**BLOCK 4N CENTRAL PARK – Section 96 Submission  
ARCHITECTURAL DESIGN STATEMENT**

20th January 2016

01 Cladding Type H3 - Typical Hotel Slot Facade - Section  
1:20

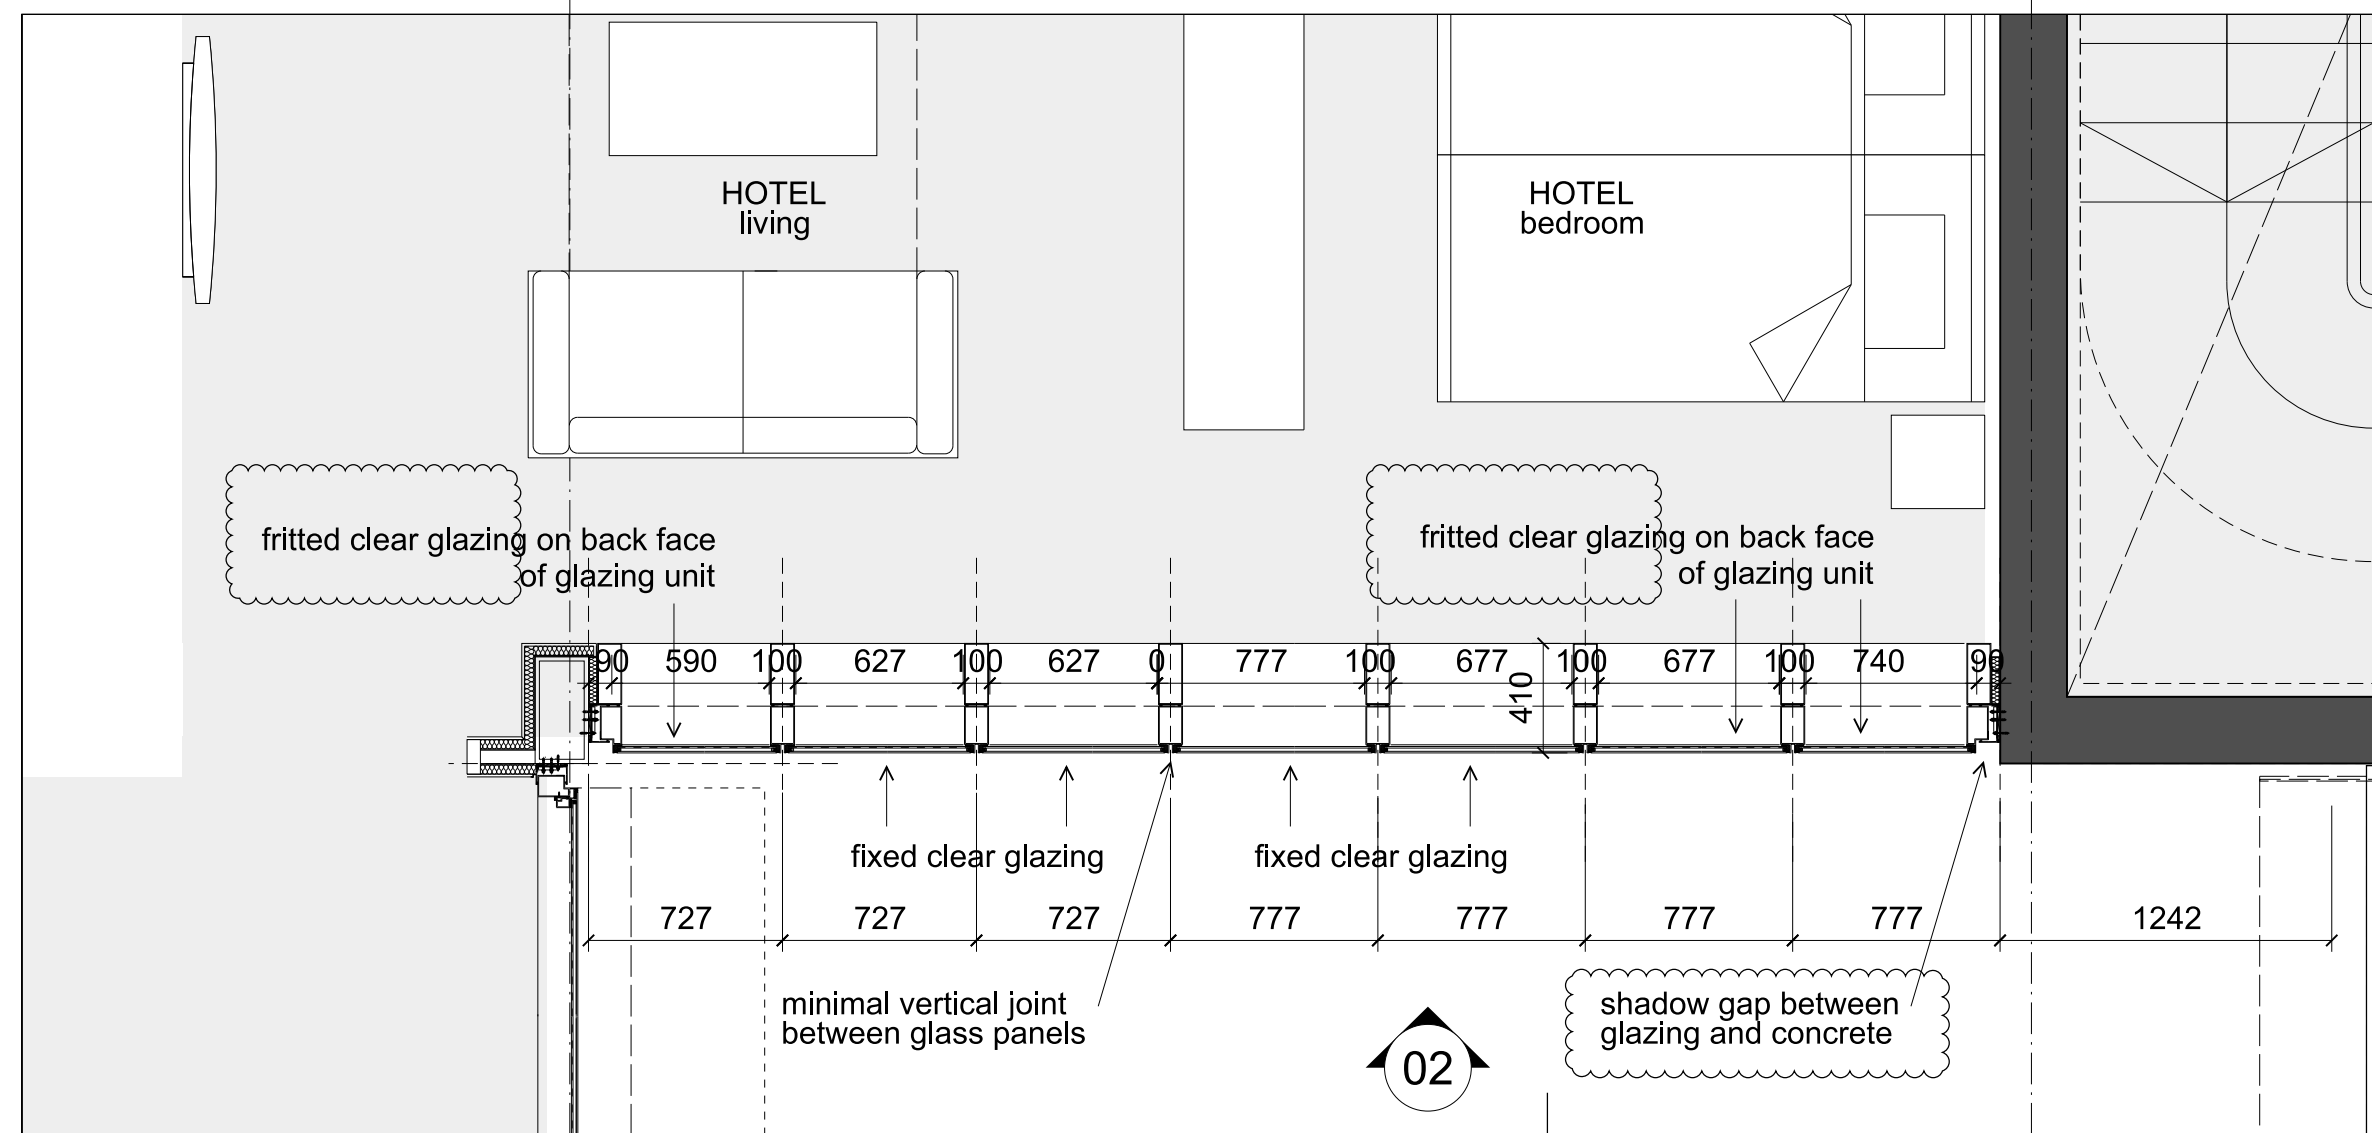
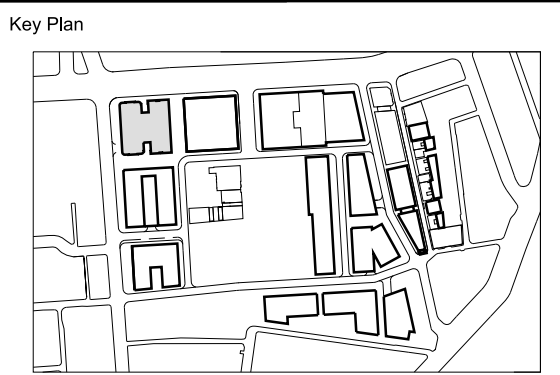
**Podium** At the building 'podium' and recessed 'neck' area level 3 the design of certain areas has been revised in terms of the use and as a consequence we have made revisions to the massing, general arrangement and composition of the facades in order to provide a more suitable layout to cater for the updated Hotel Brief. The internal levels of the first and second floor have been amended to suit the increased conference room facilities and their requirement for larger ceiling voids. This has resulted in a reorganisation of the location of the clear vision glass zones, shadow boxes, spandrel panels, canopies and horizontal metal louvers throughout the height of the podium facades to better suit the updated hotel room functions and layout behind.

Block 4N
External Wall System
Typ. Childcare Balcony Facade
Cladding Type O2

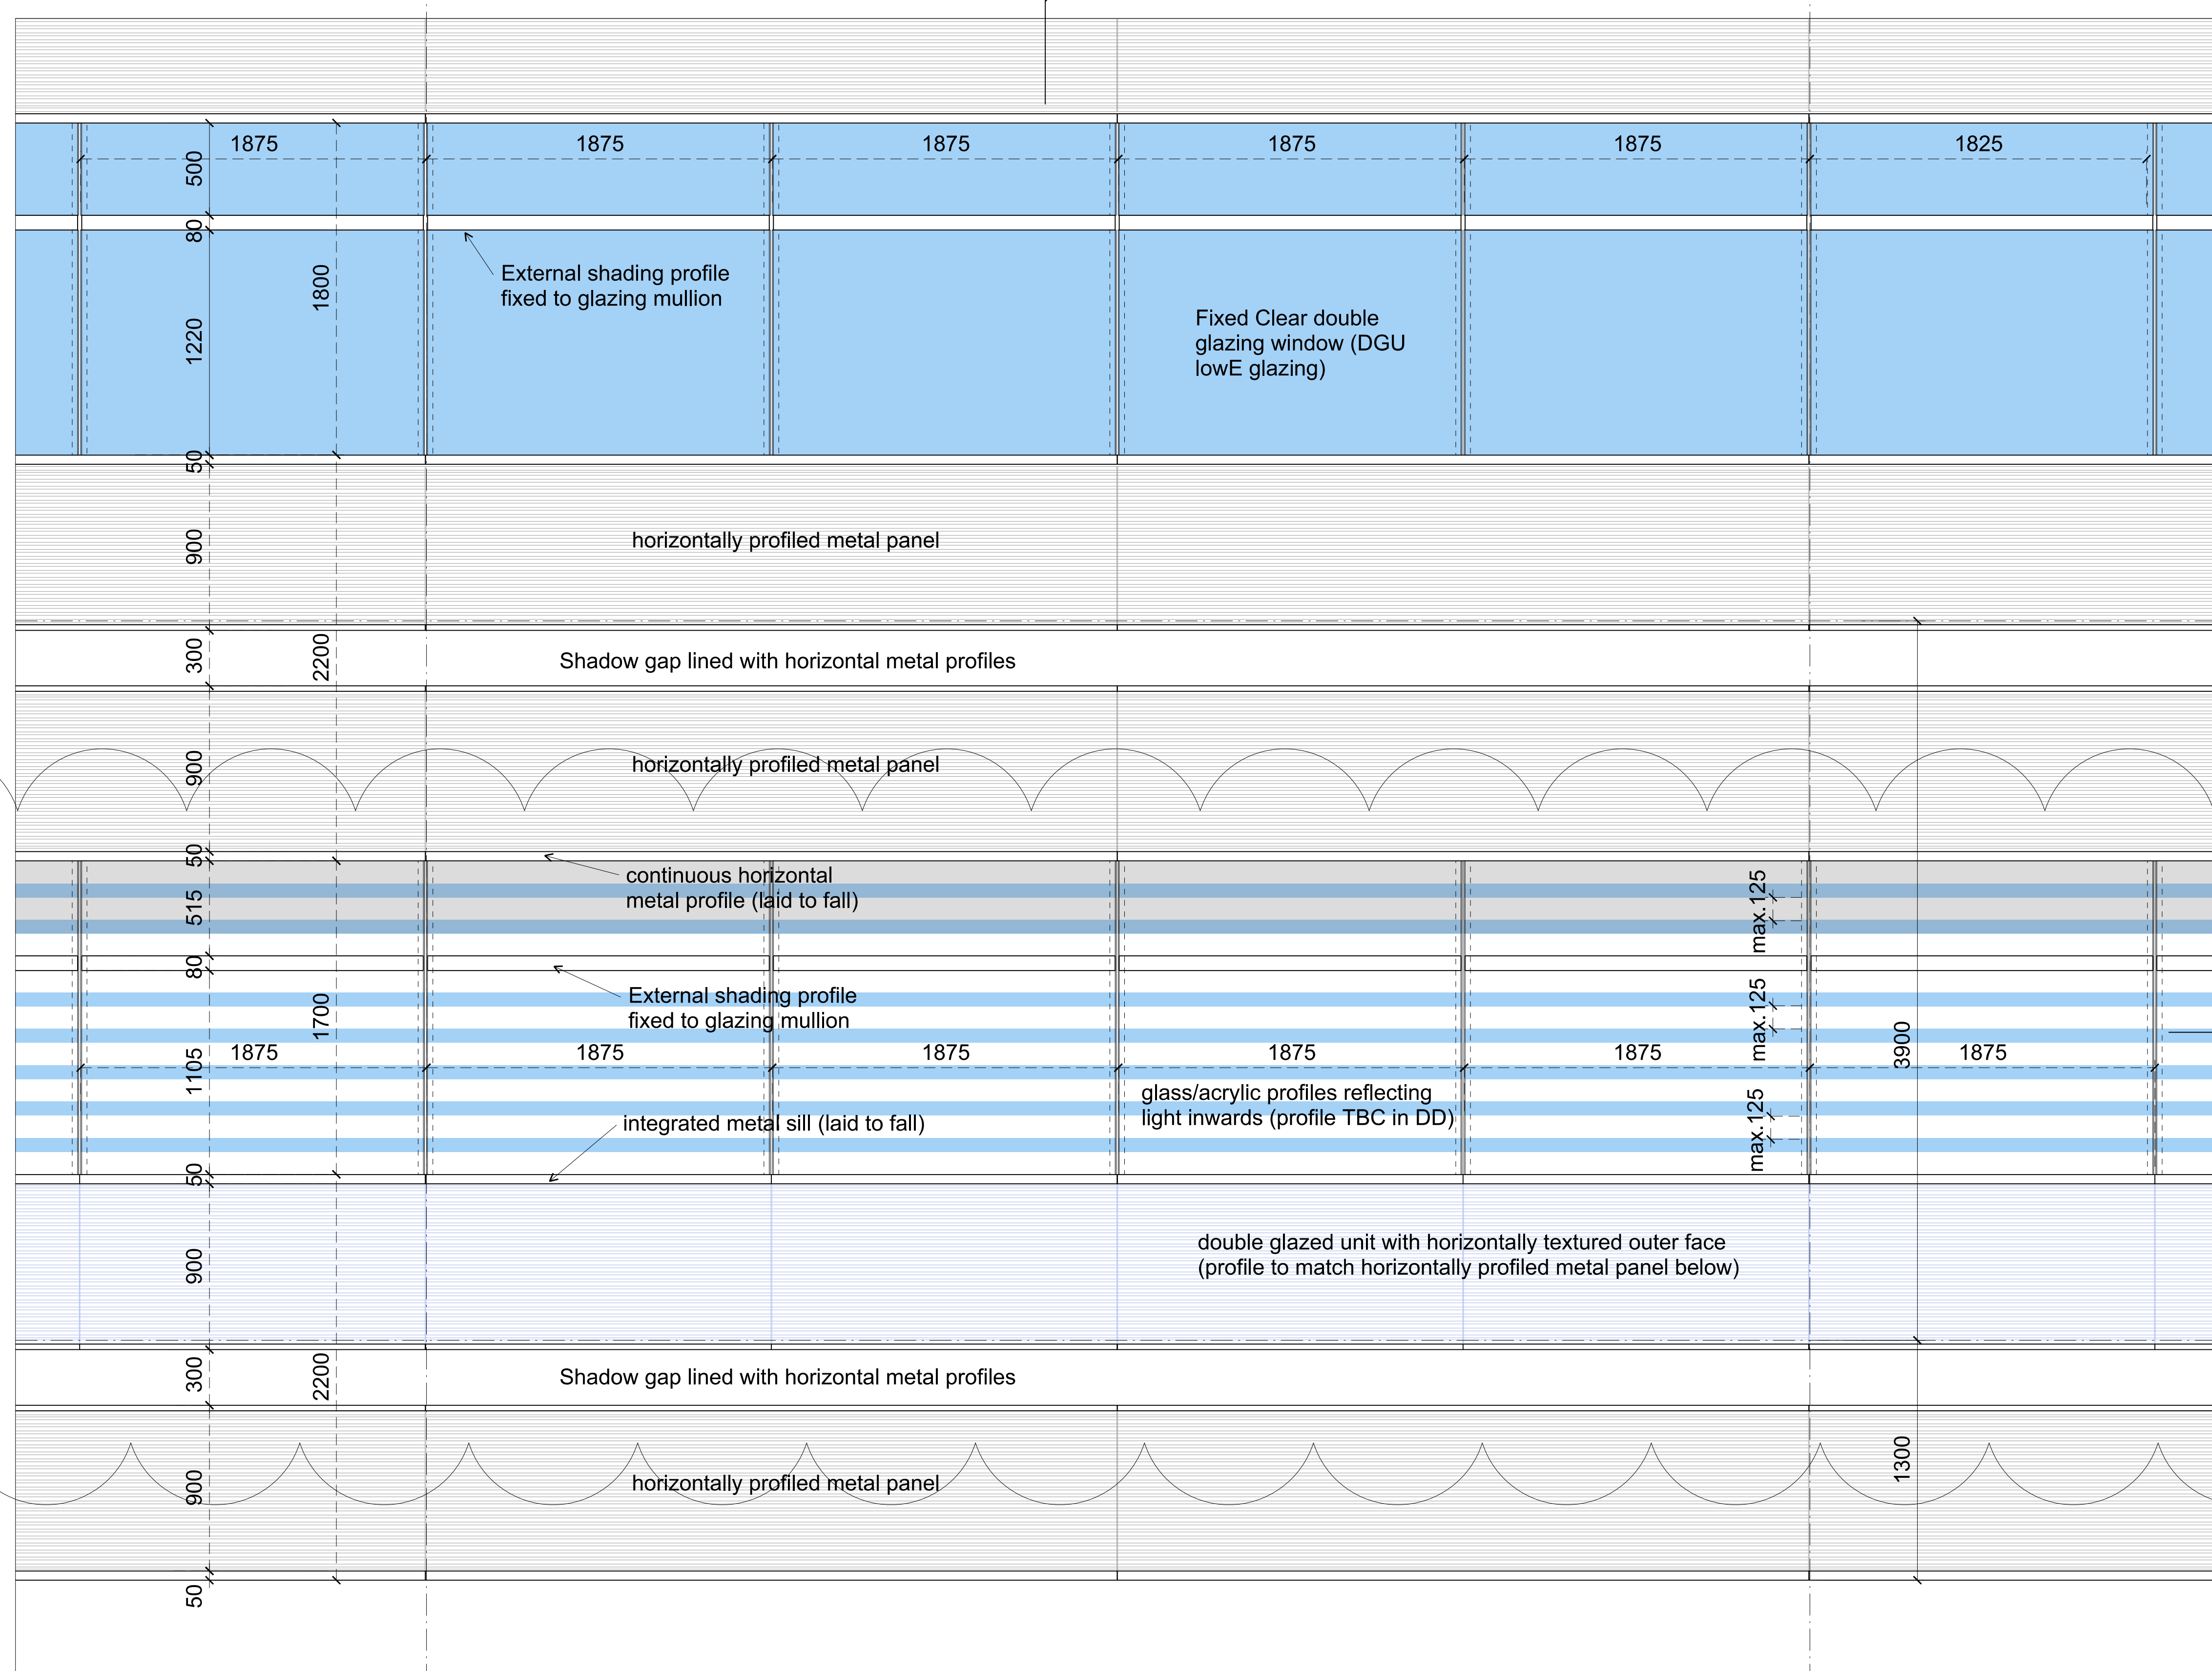
A final amendment can be found within the façade system enclosing the external Childcare terraced areas on level 4; where the glass tubes above the textured glass parapet have now been suggested to become thick glass louver blades instead.
